**RE: Juan Tabo Hills Estates Preliminary Plat, Project # 1005278**

The purpose of this letter is to explain how the comments as contained in the DRB Official Notice of Decision (May 21, 2015) have been addressed. The following items have been revised and are being re-submitted for review and approval.

1. Preliminary Plat (including Sheet 1 Vacation Exhibit),
2. Infrastructure List,
3. Sidewalk Exhibit
4. Perimeter Wall Detail
5. Grading and Drainage Plan

CITY PROJECT NO. _____ ZONE MAP NO. _____ SHEET OF _____
M-21-Z 2 10

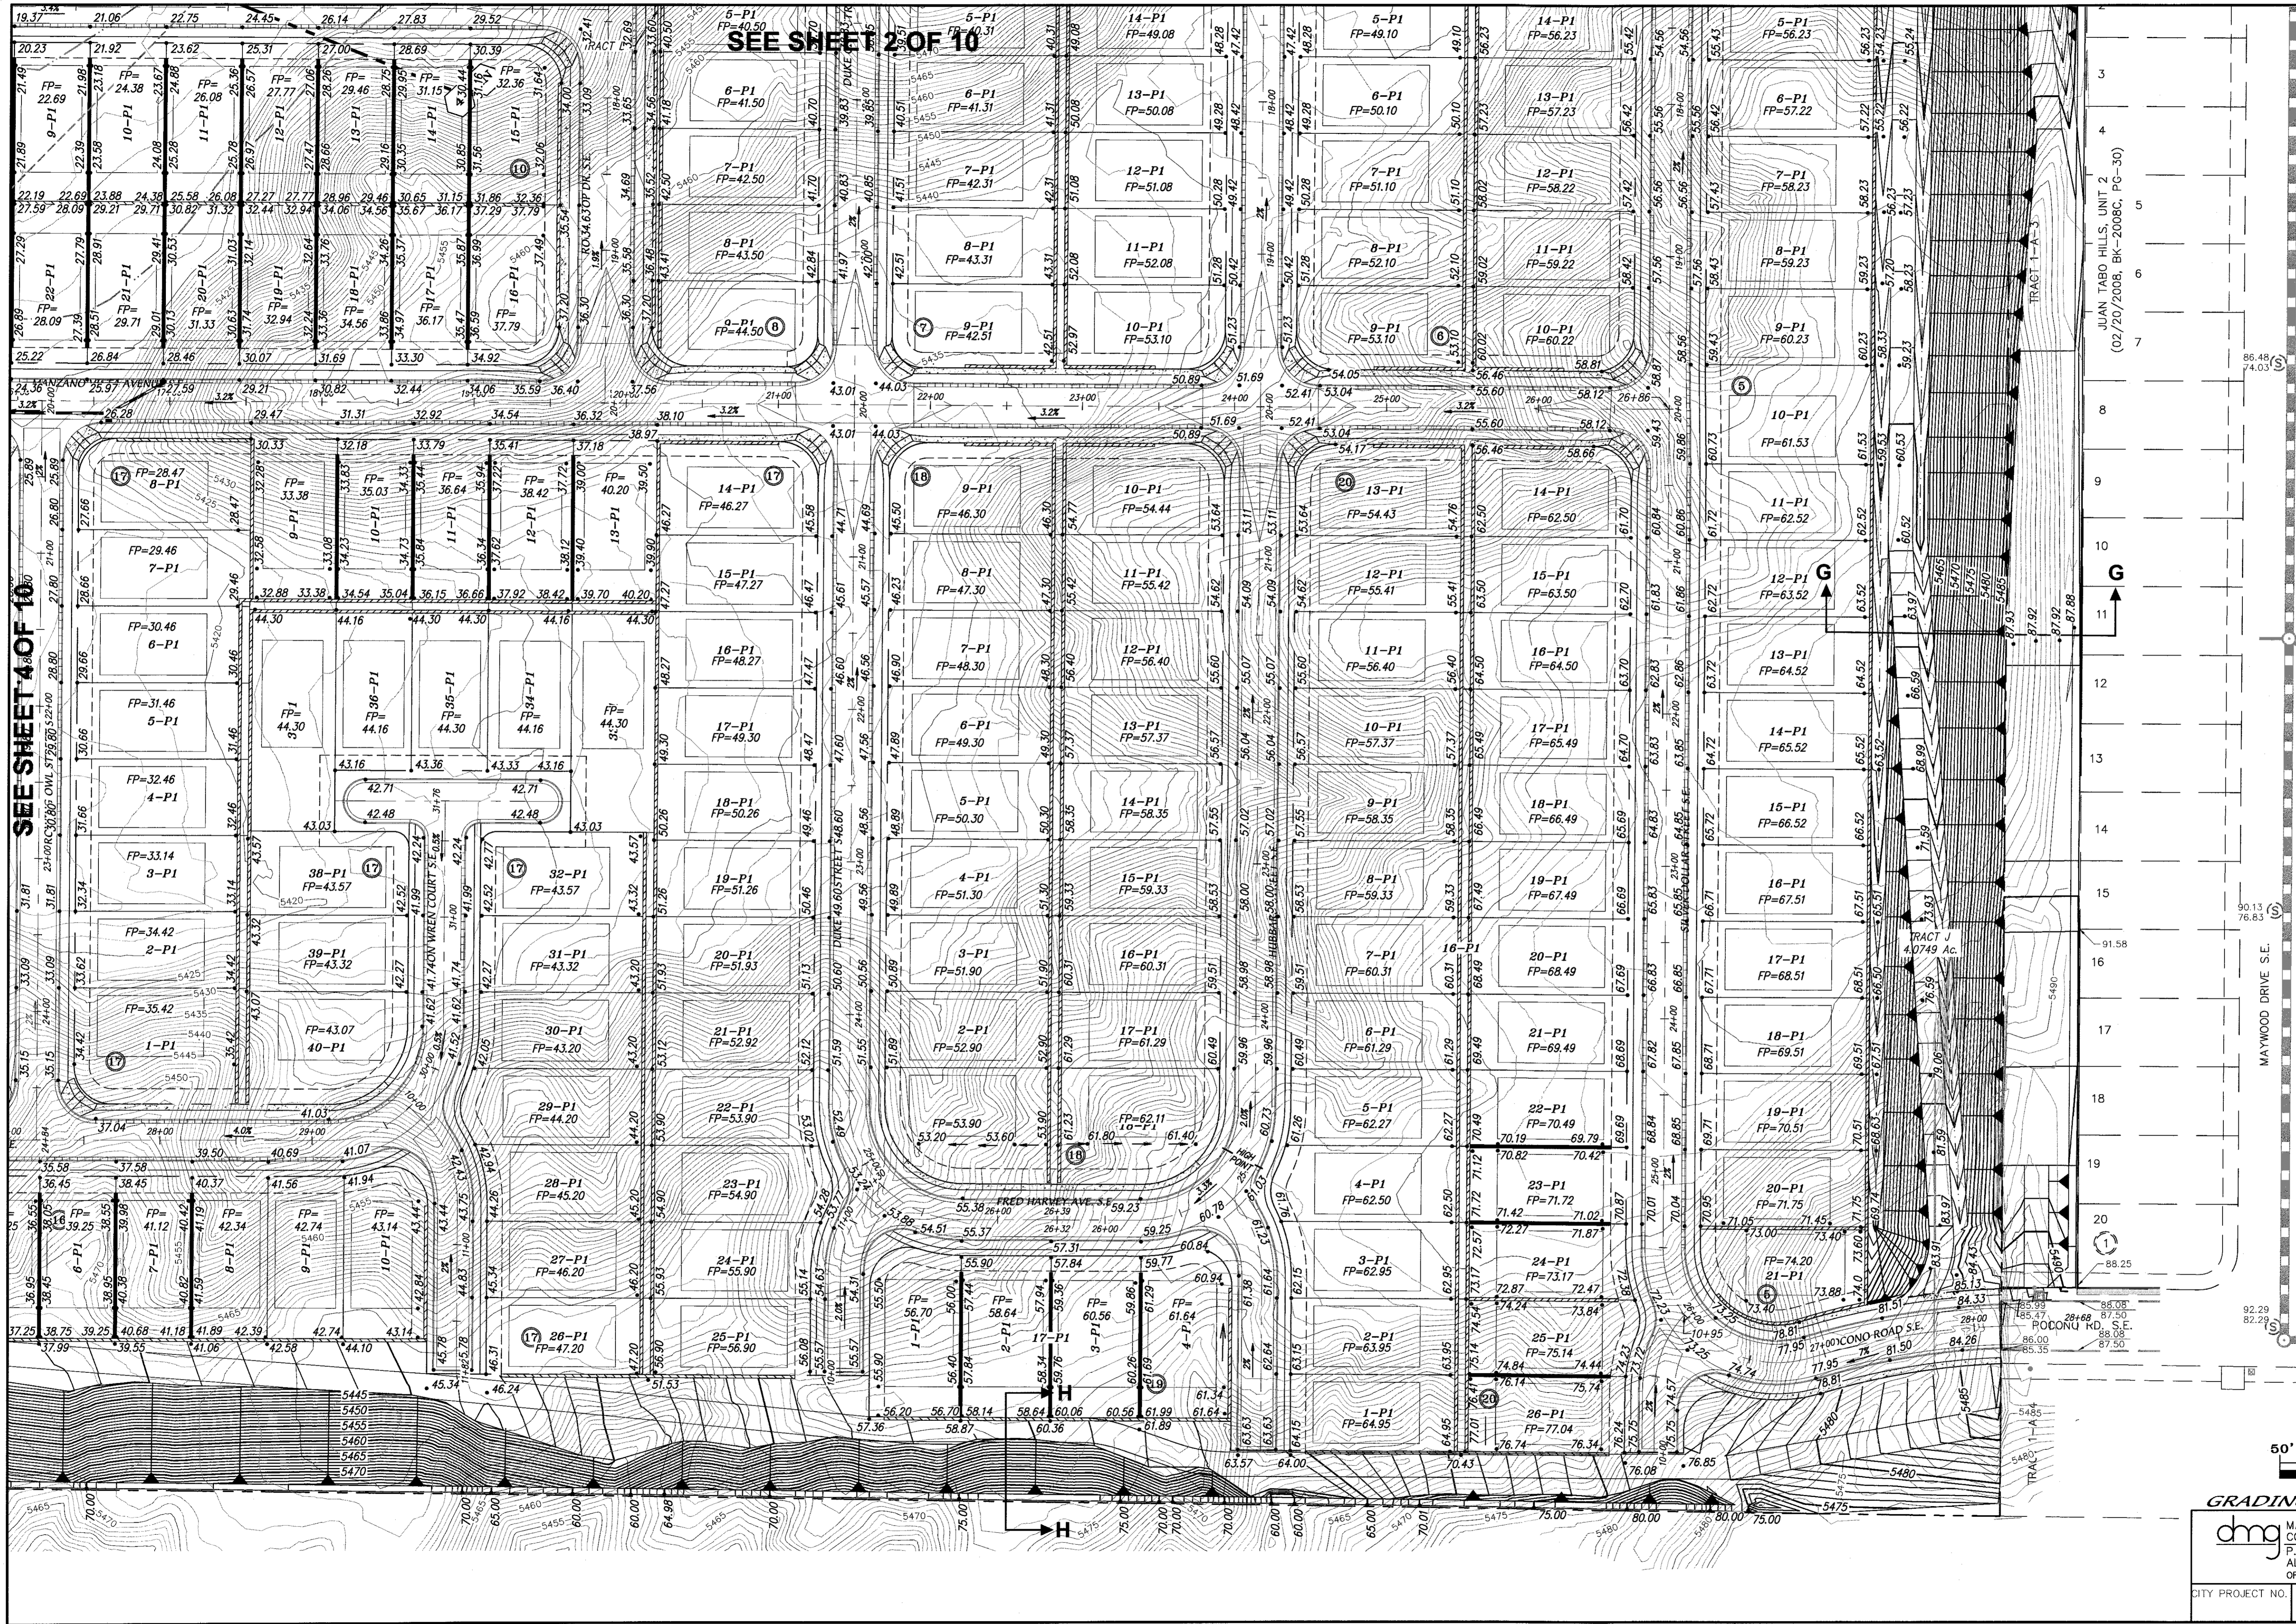
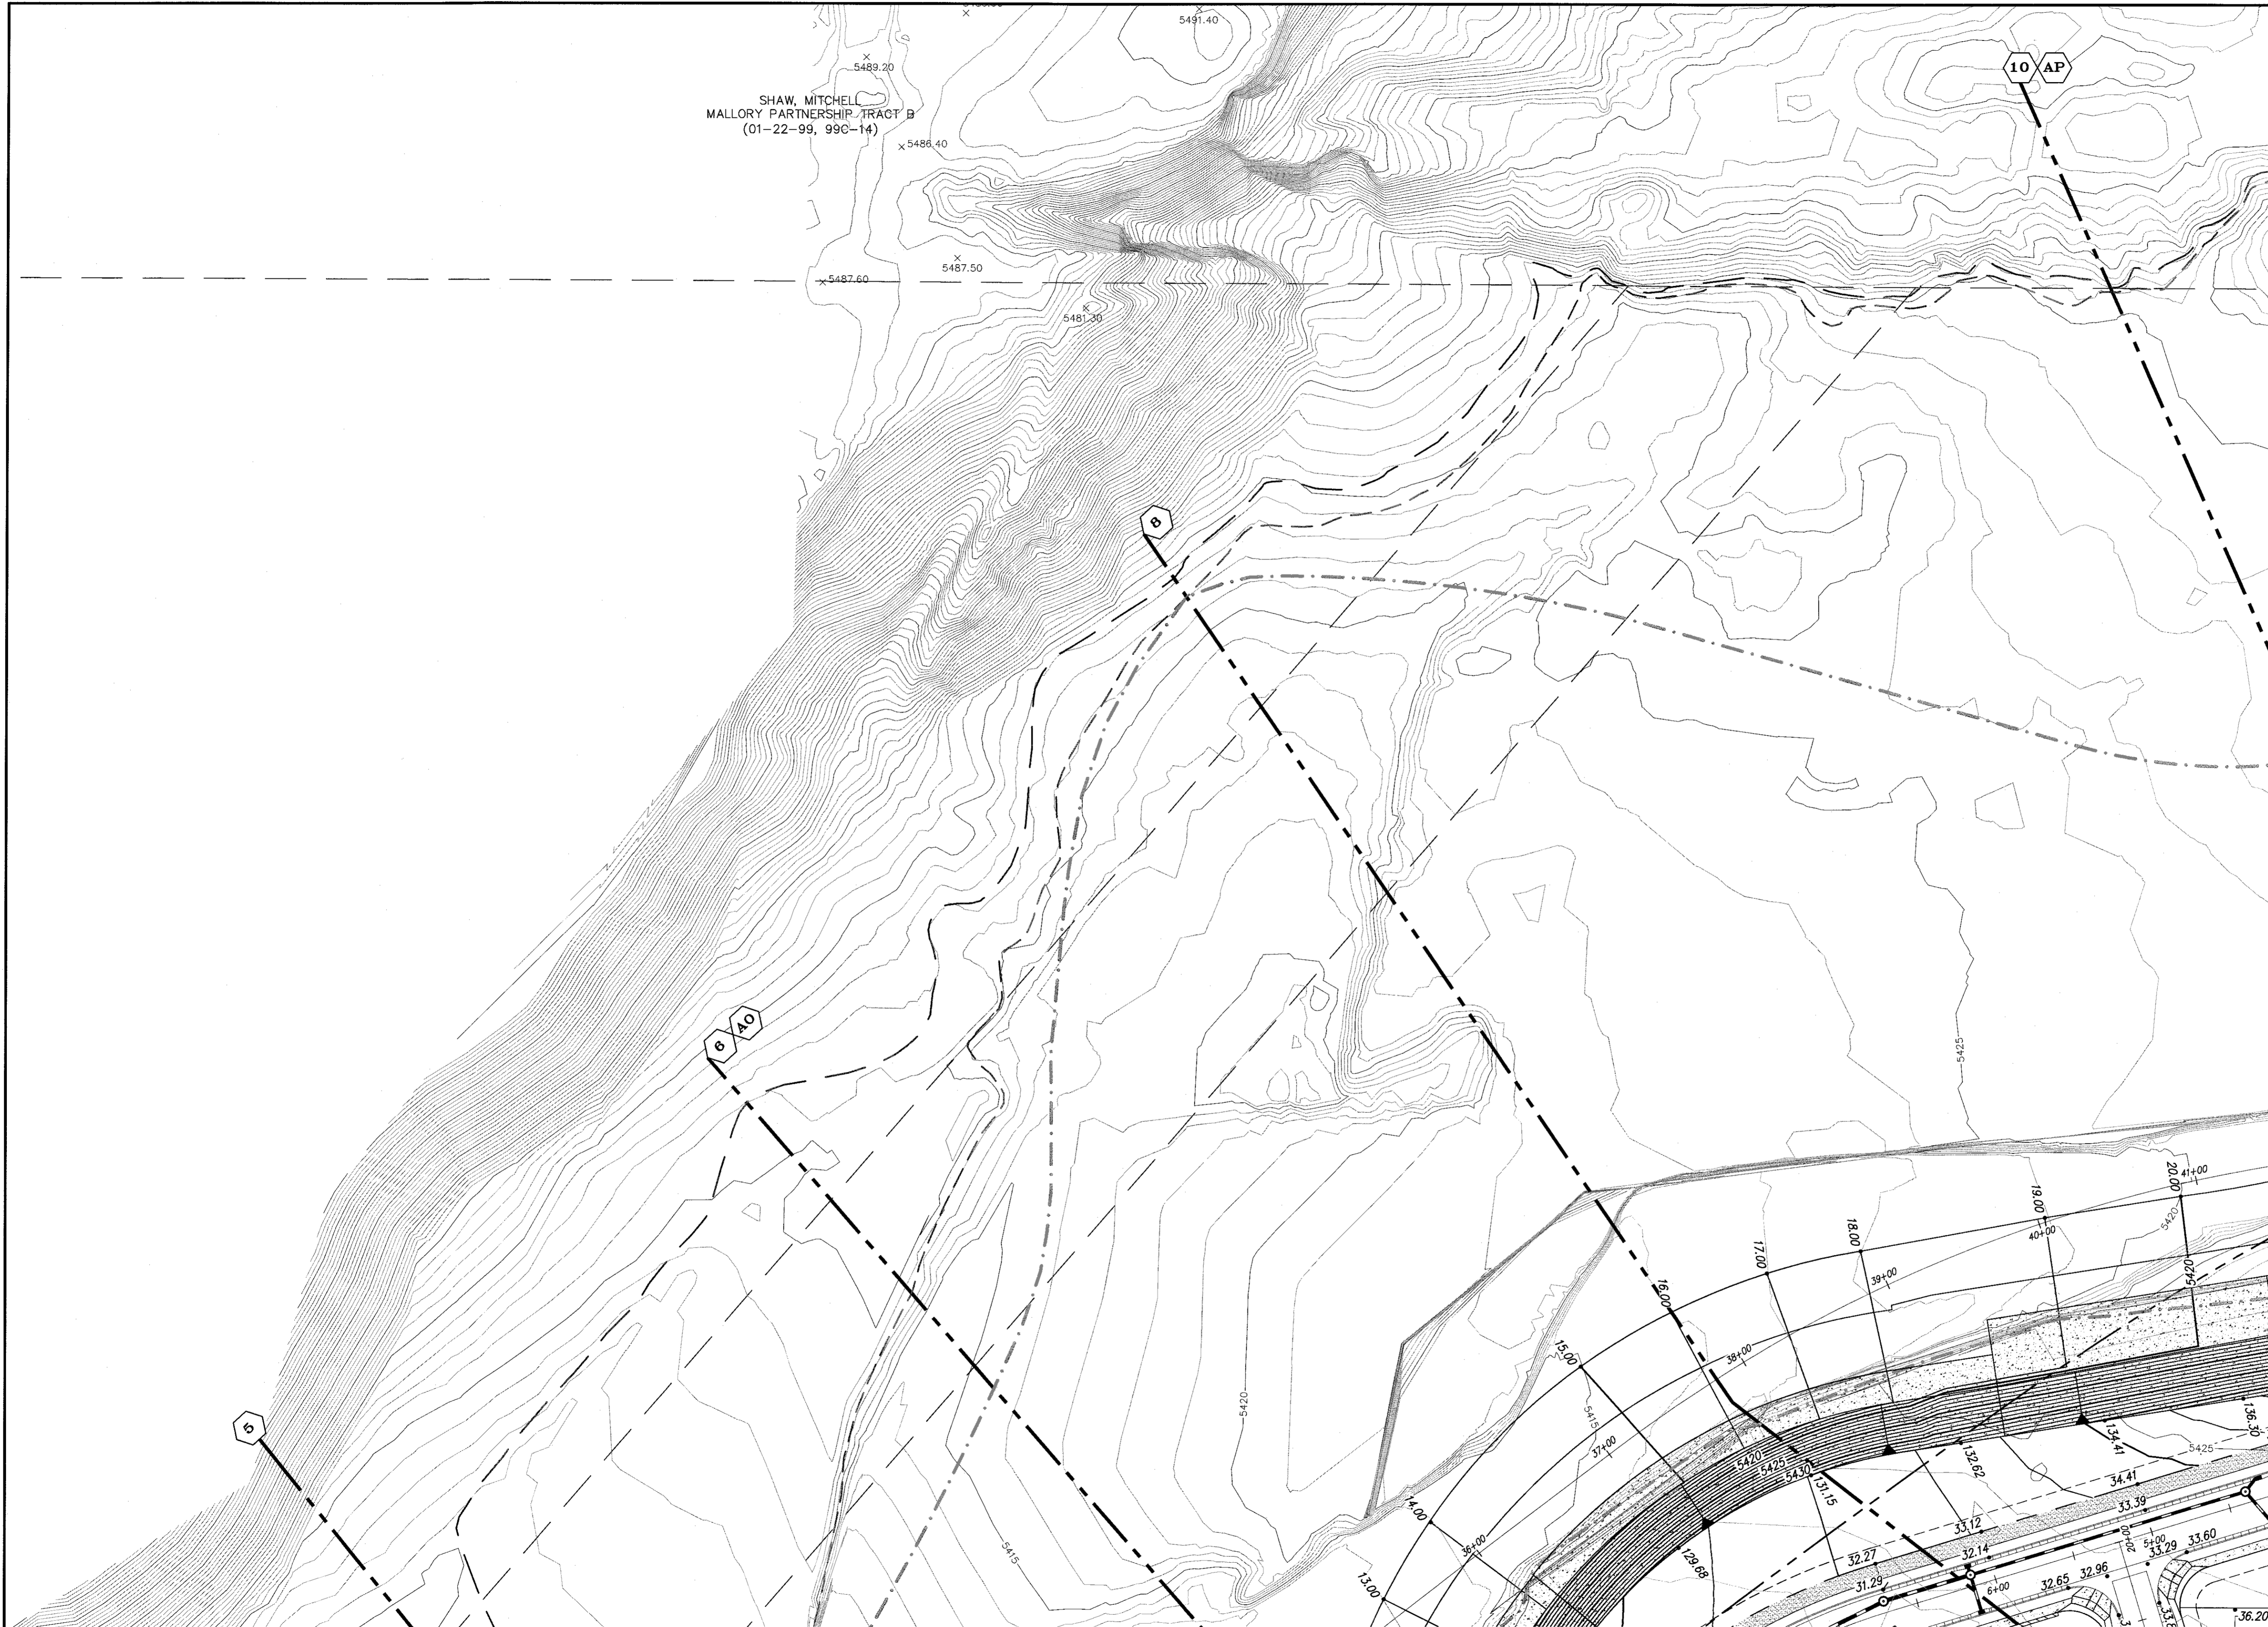
Parks and Recreation comments (1.) requesting changes to the landscape plan are now not applicable since the Landscape Plan and Tract A have been deleted from the site plan, though some separate exhibits have been provided to Carol Dumont to aid in her review. (2.) Previous agreement(s) say that the privately maintained Neighborhood Park is a private park which will be owned and maintained by the HOA. The private park is not subject to City review and approval and so has not been added to the infrastructure List (3.) The signature block on the infrastructure list has been changed to read Parks and Recreation Department. (4.) The Memorandum of Understanding between the USACE and the NMSHPO was distributed to DRB members during the first DRB meeting which outlines the approved plan of action for compliance with all cultural resource regulations (federal, state and local). (5.) The underground utilities are on the Infrastructure list and an updated copy of the Conceptual Utility Plan has been provided to aid in the review of the Infrastructure List. Contours and spot elevations have been

added to the Grading Plan. Separate permits will be obtained from the Corps of Engineers and AMAFCA that will address fencing along the arroyo. (6.) Ten foot wide AC Trails have been added to tracts H and J and are located in the best place available to insure privacy of the residents. AMAFCA has no objection to the approval of the Preliminary Plat and will be reviewing more detailed plans after Preliminary Plat Approval keeping in mind federal water quality standards and regulations.
